# Rezoning Transportation Analysis

Petition Number: 2022-219

**From:** Jake Carpenter, PE

## Revision Log:

RZ-1.0

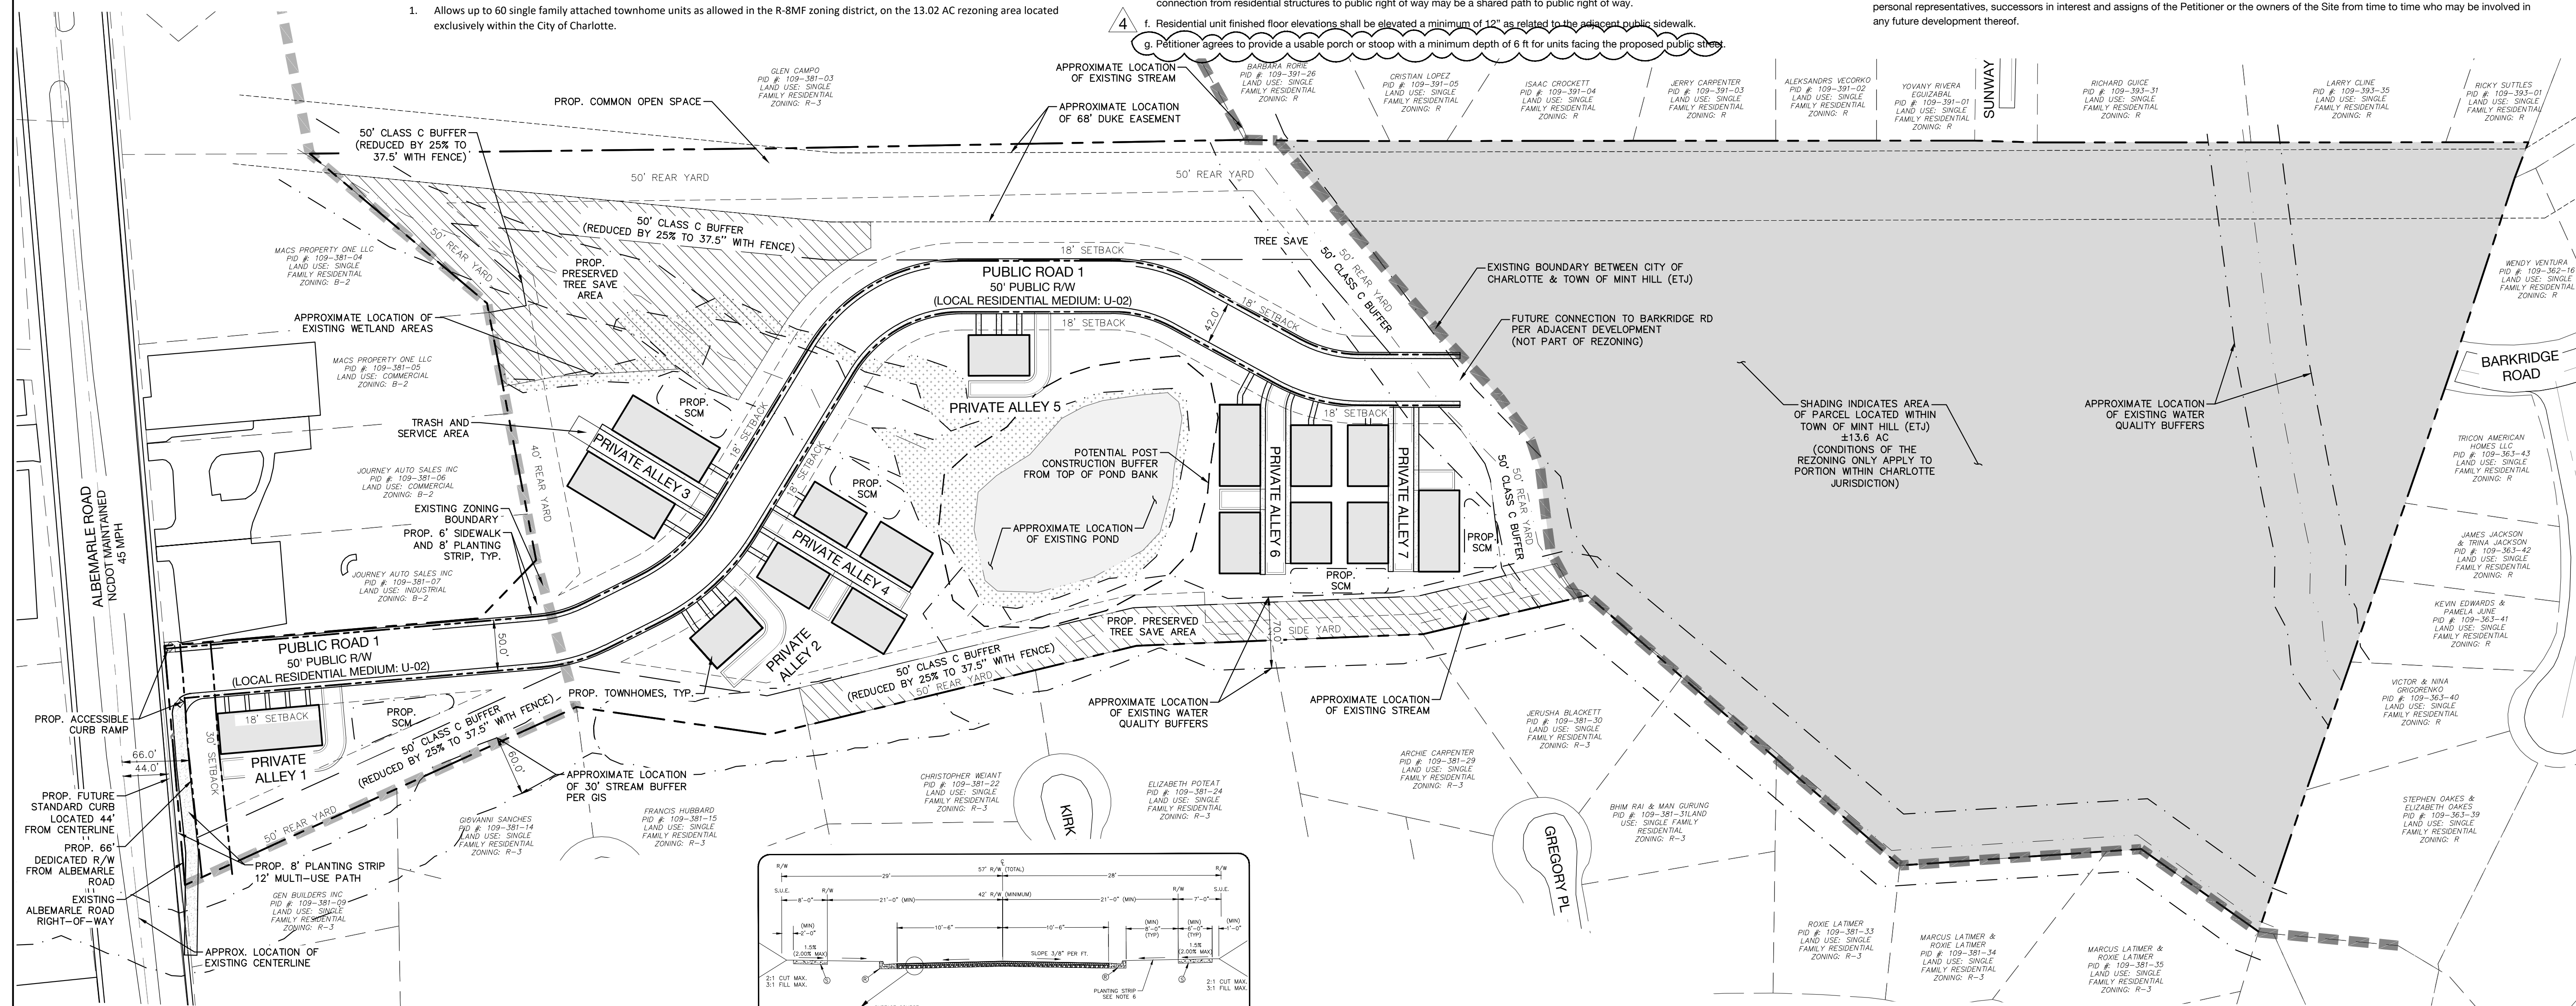
- 3. Revise site plan and conditional note(s) to commit to dedicate 66' right-of-way from the road centerline or 64' with a 2' SUE. The site plan shall label and dimension the right-of-way from the road centerline.

**Clarifying comment from 6.21.2023:** Add conditional note to dedicate 66' right-of-way from the road centerline.

8. CDOT requests petitioner revise site plan and conditional note(s) to commit to constructing a right turn lane on Albemarle Road per coordination with NCDOT due to volume and speed in this area of the city.  
**Clarifying comment from 6.21.2023:** In coordination with NCDOT, label and add a conditional note to constructing a right turn lane on Albemarle Road.
9. CDOT requests petitioner revise site plan and conditional note(s) to commit to building Public Road 1 to the Local Residential Wide Street Section (CLDSM U-03A).

**Clarifying comment from 6.21.2023:** Revise site plan and conditional to commit to constructing Public Road 1 to a Local Residential Wide Street Section (CLDSM U-03A).

10. Add a conditional note specifying “the Petitioner shall dedicate and convey in fee simple all rights-of-way to the City before the site’s first building certificate of occupancy is issued. CDOT requests rights-of-way set at 2’ behind back of sidewalk where feasible.”  
Update conditional note 5 under “Transportation” to have SUE 2’ behind MUP instead of 1’ as shown. 2’ is necessary for the maintenance of the path.

**Clarifying comment from 6.21.2023:** Revise conditional note with SUE to have 2’ instead of 1’ as shown in conditional note 7. 2’ is necessary for the maintenance of the path.

13. Revise site plan and conditional note(s) to better illustrate what conditional note 3 under “Transportation” is referencing. It states ADA ramps will be provided at the corner of Public Road 1 and Albemarle Road as illustrated but there is not illustration of this proposed improvement.

**Clarifying comment from 6.21.2023:** Clearly show and label accessible curb ramps at the corner of Public Road 1 and Albemarle Road.
